CONSULTEE RESPONSE (Council's Arboriculturist)

Reference: FG/62/26/HH

Proposal: Proposed detached garden room.

Location: 1 Greenways Crescent, Ferring, BN12 5EF

PROPOSED FOUNDATION PLAN 1:50

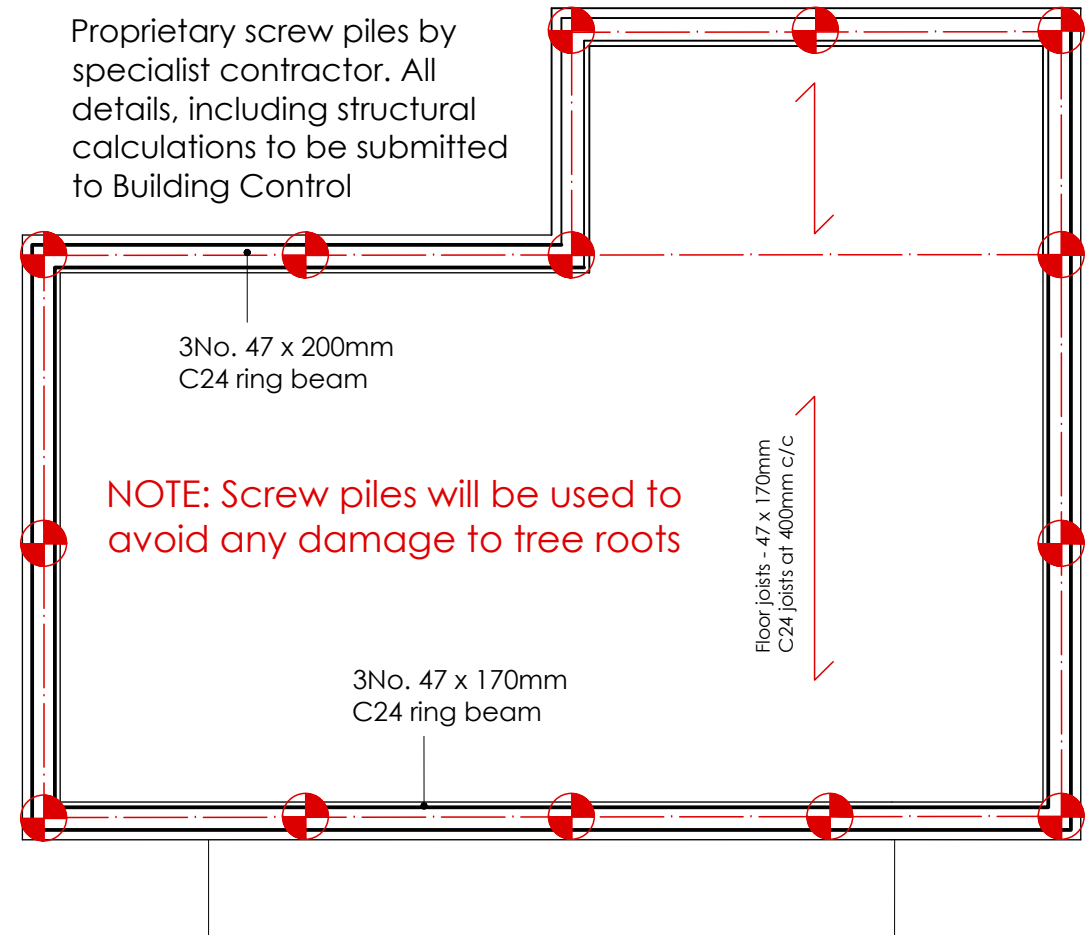
Any construction work proposed within the nominal root protection area of a retained tree may require a specialised engineering solution (e.g. raft and or screw pile foundation).
